Land at Bilsham Road, Yapton
Planning Reference: Y/70/22/DOC

Approval of details reserved by condition imposed under ref Y/91/17/OUT relating to Condition Nos 9 - surface water drainage and 27 relating to levels.

At this stage we would recommend that these conditions are not discharged at this time until further information is provided and the comments below are addressed

Drawing Status	FOR APPROVAL		
Client	THAKEHAM		
Project	BILSHAM ROAD YAPTON		
Drawing Title	S104-CONSTRUCTION DETAILS SHEET 1 OF 2		
Scale	NTS	Date	FEB 22
Drawn By		Checked By	
Drawing No.	D1956-15-100		
Rev.	-

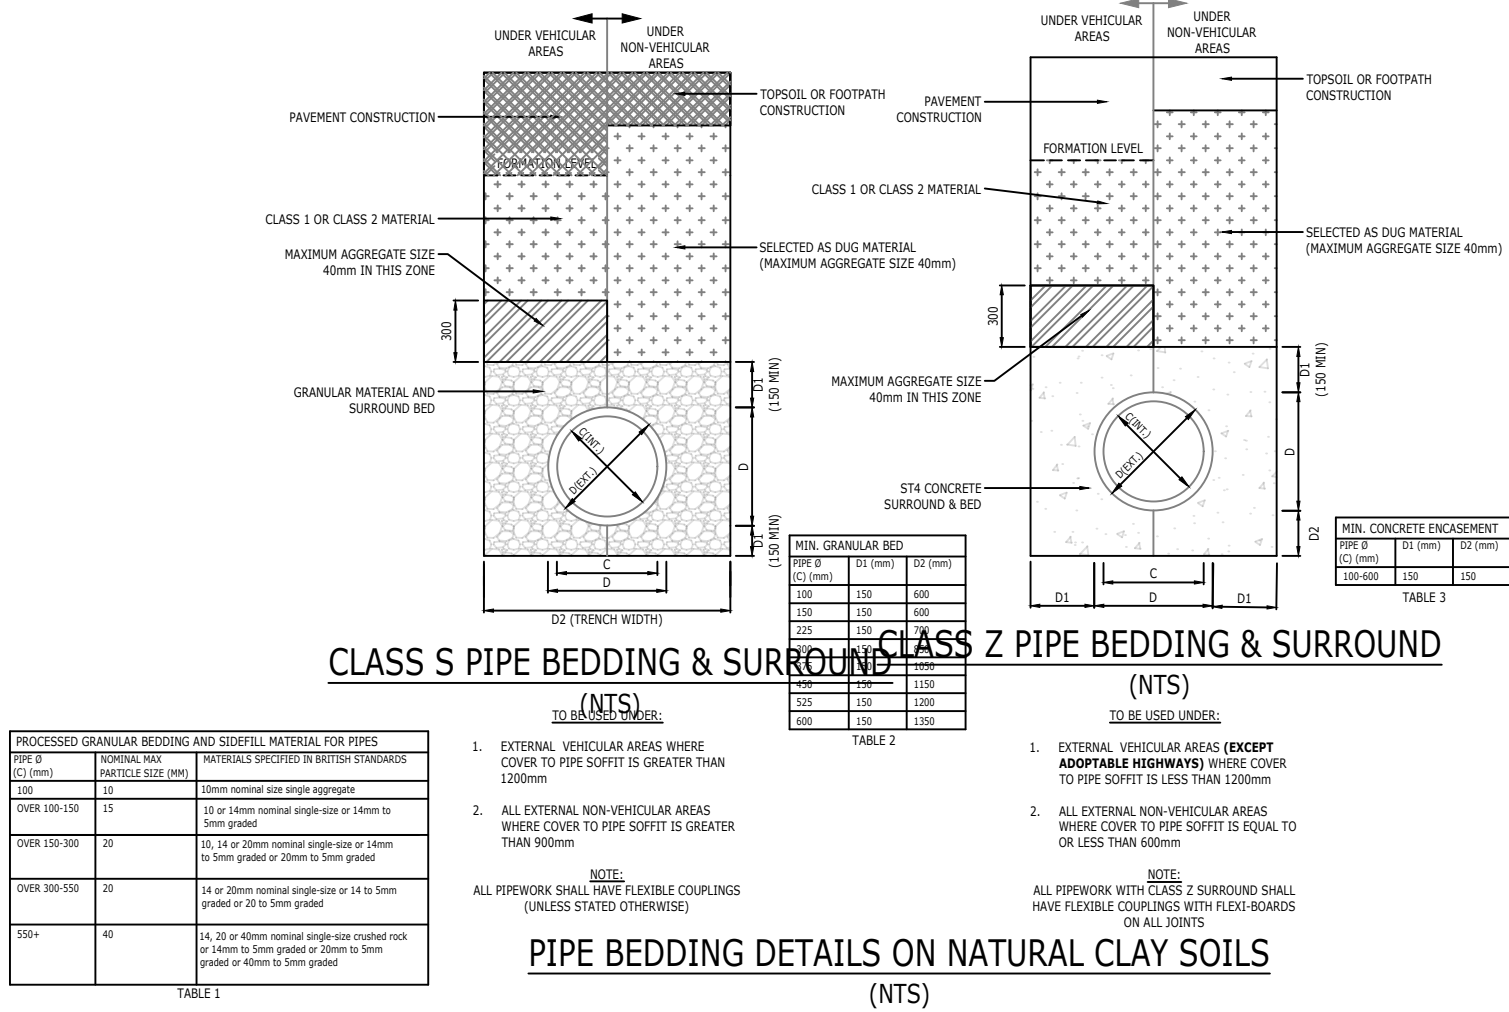
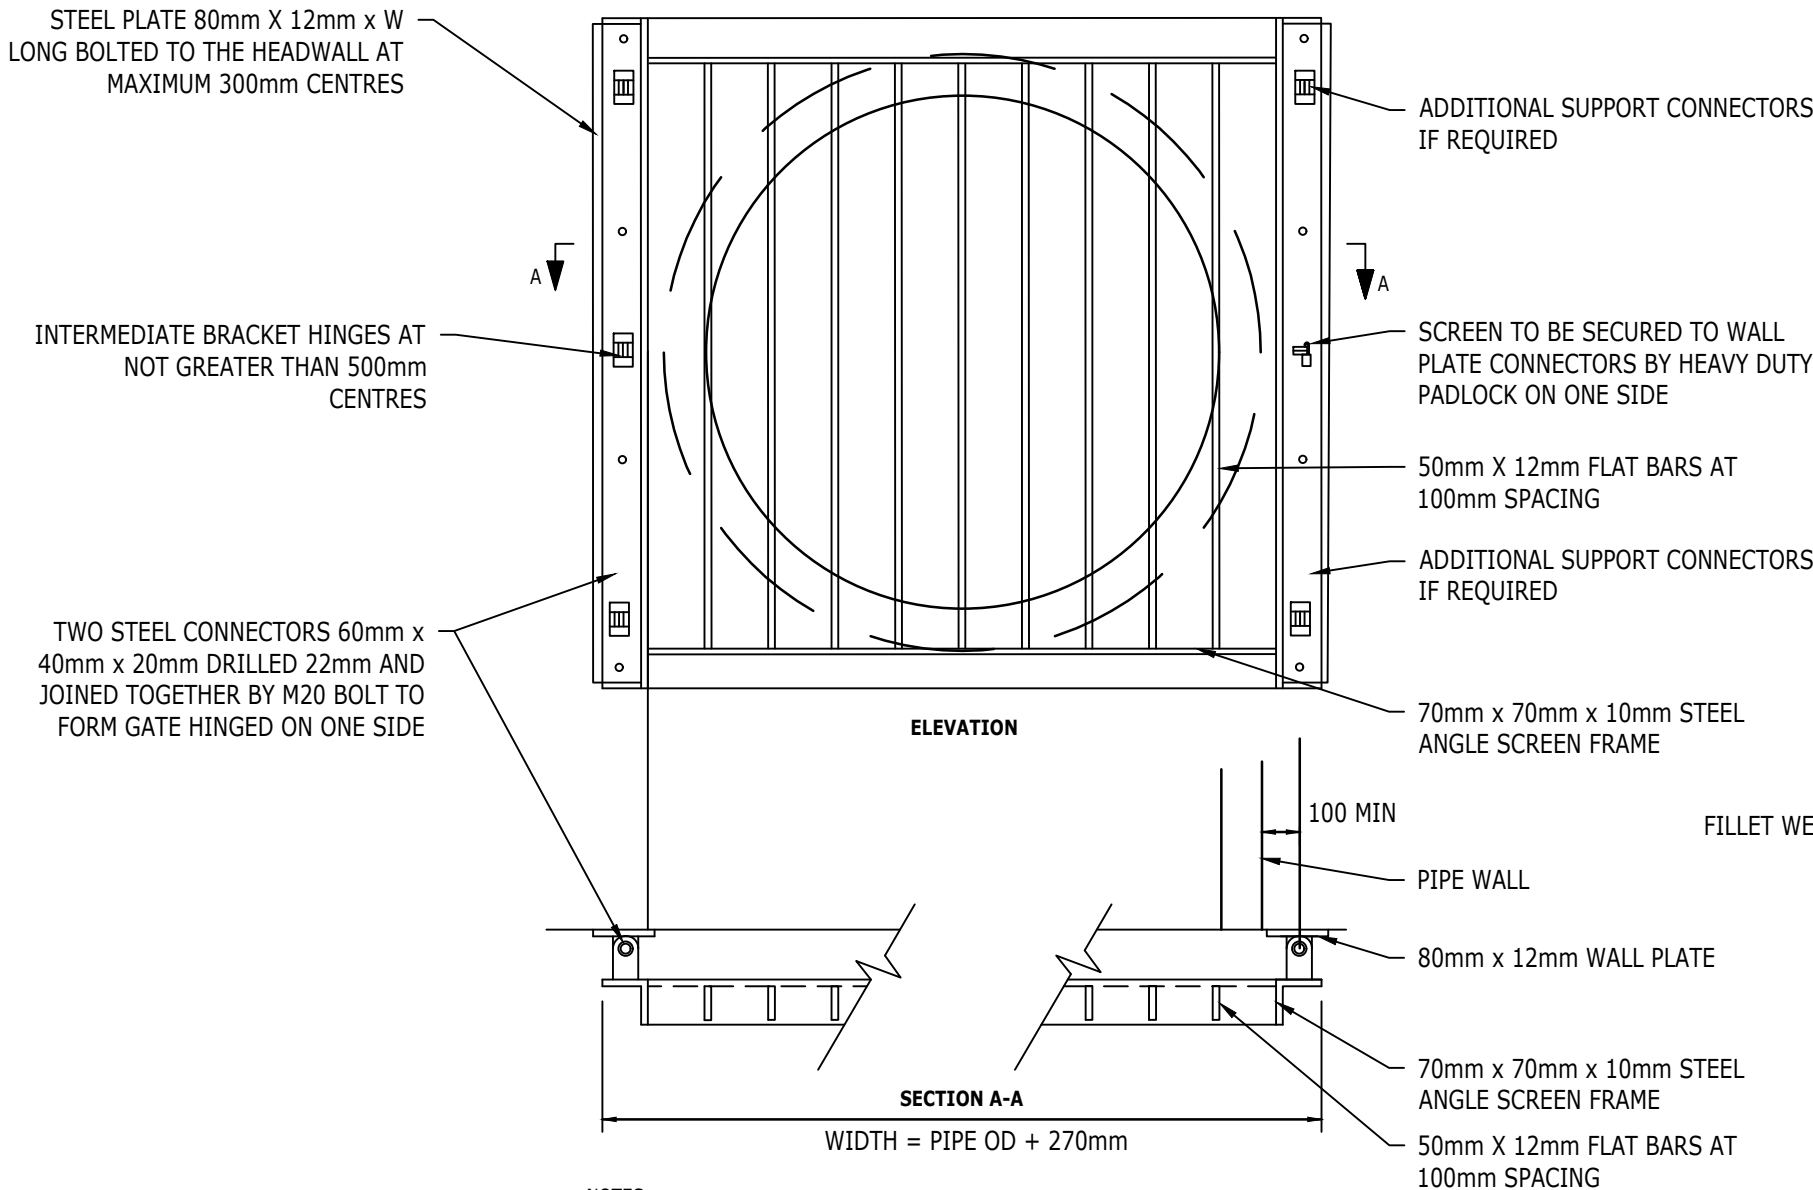
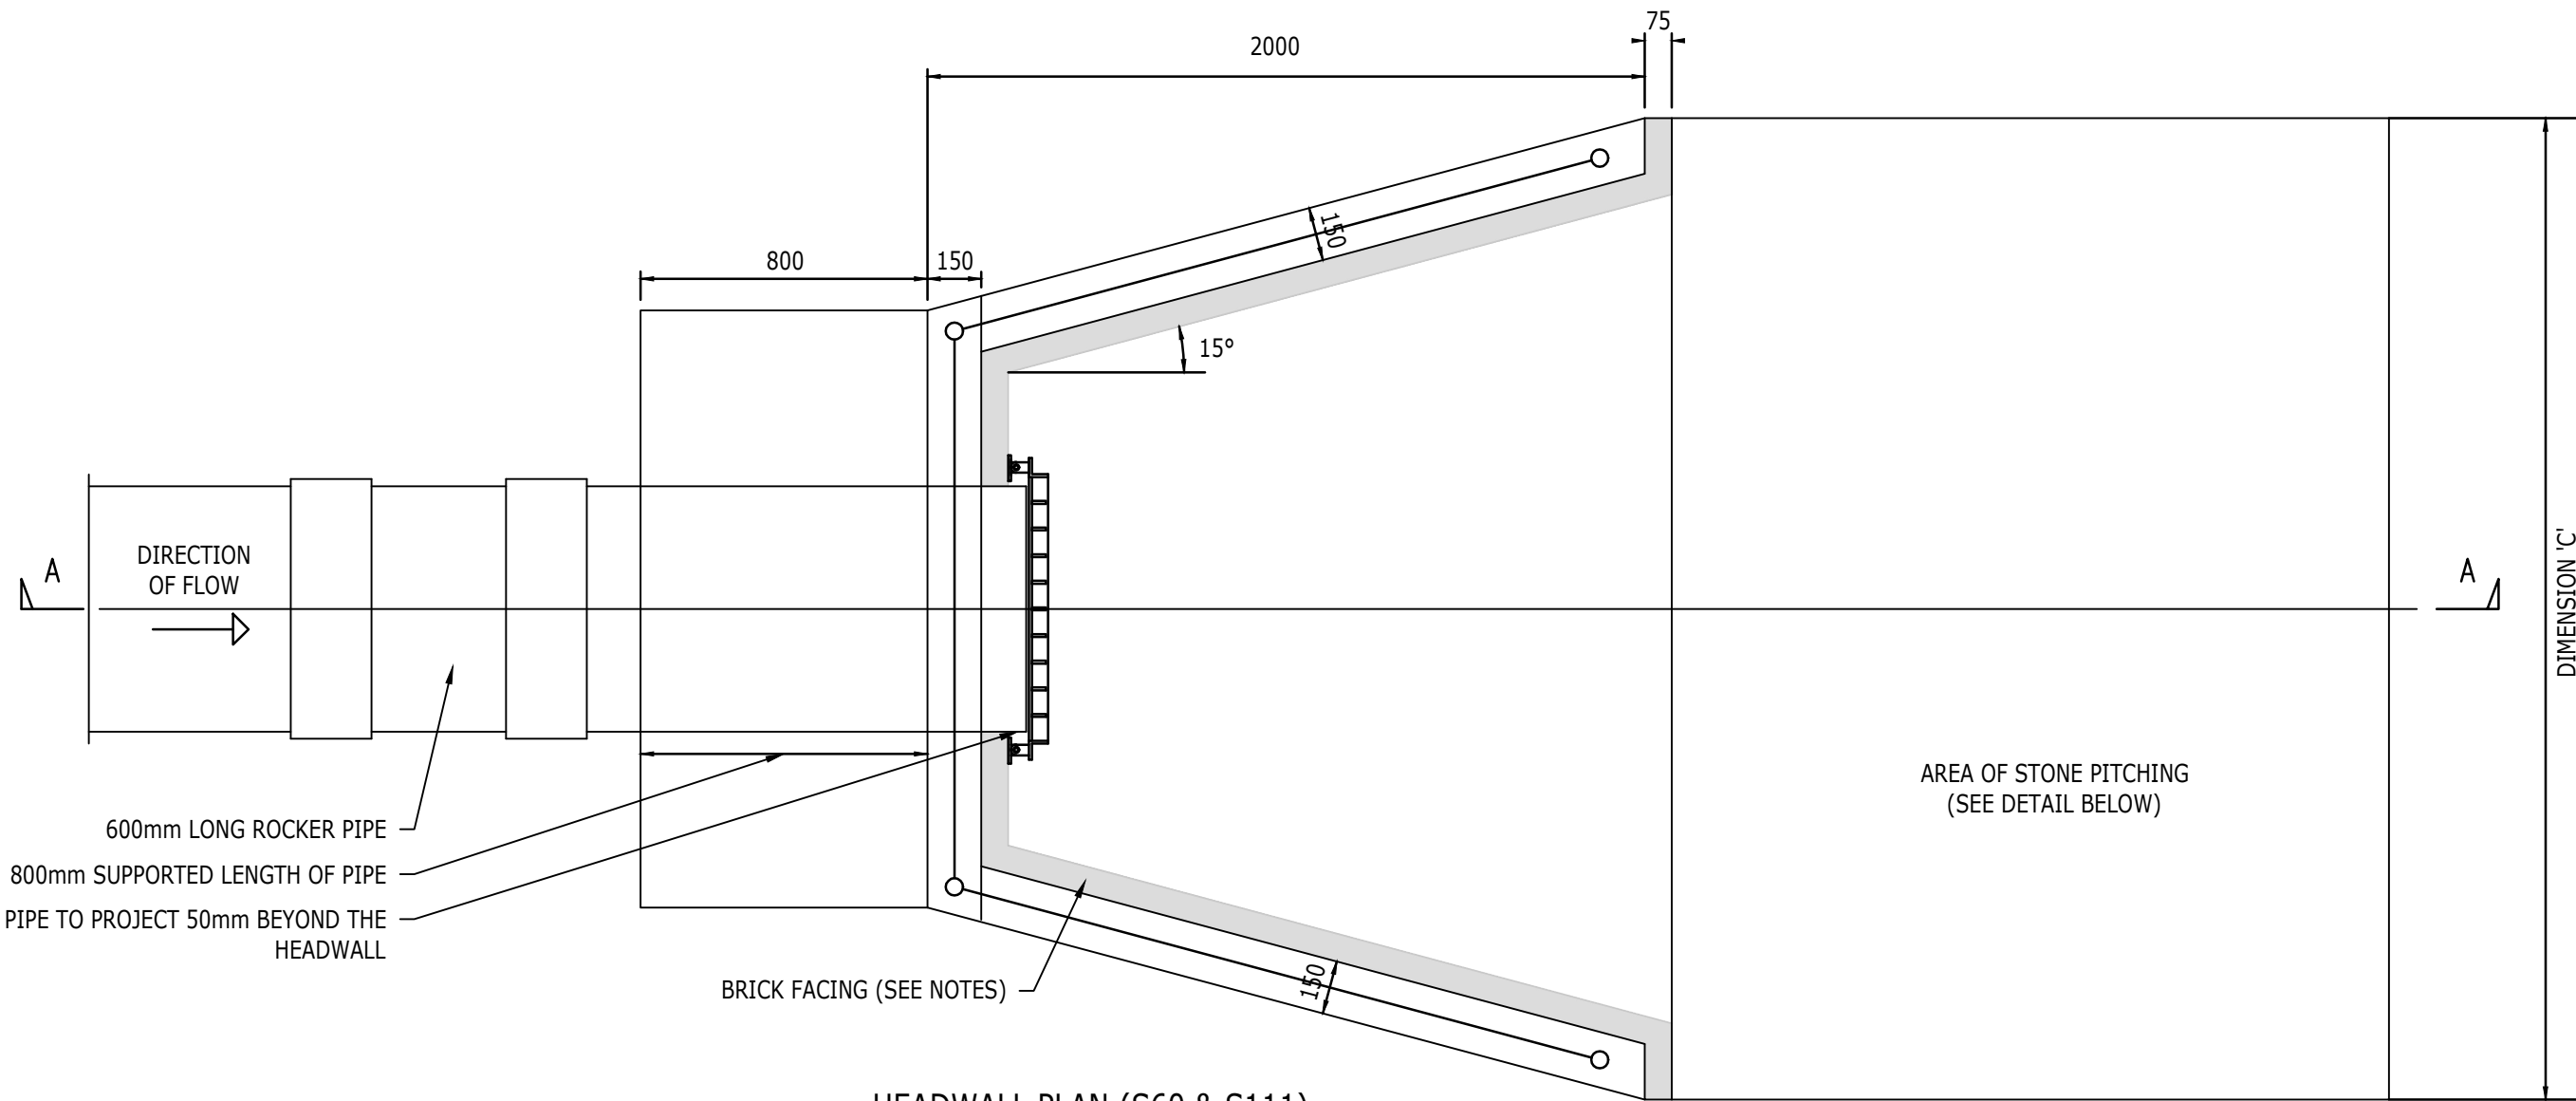
11. *Please provide cranked grilles at a 45 degree angle. - Cranked grilles required on heads – S104 Construction details sheet 1 of 2 D1956-15-100 needs to be updated to suit ADC requirement. Pipe beddings details on this drawing are illegible in parts. Information needs to be clearly presented. We note that applicant’s response that this is not “DSG compliant” however the drawings refer to Sewers for Adoption 7th Edition. As such the applicant needs to be clear which edition of Sewer for Adoption the adoptable drainage is being designed to.*

In addition they should confirm who the adopting authority will be as well as confirmation from the adopting authority on whether they will or will not accept cranked grilles.

08/02/2023- Whilst it is noted that the Technical Approval certificate has been provided for information, this doesn't clarify whether the adopting authority has considered a request to use cranked grilles. This needs to be confirmed by the adopting authority otherwise cranked grilles should be used
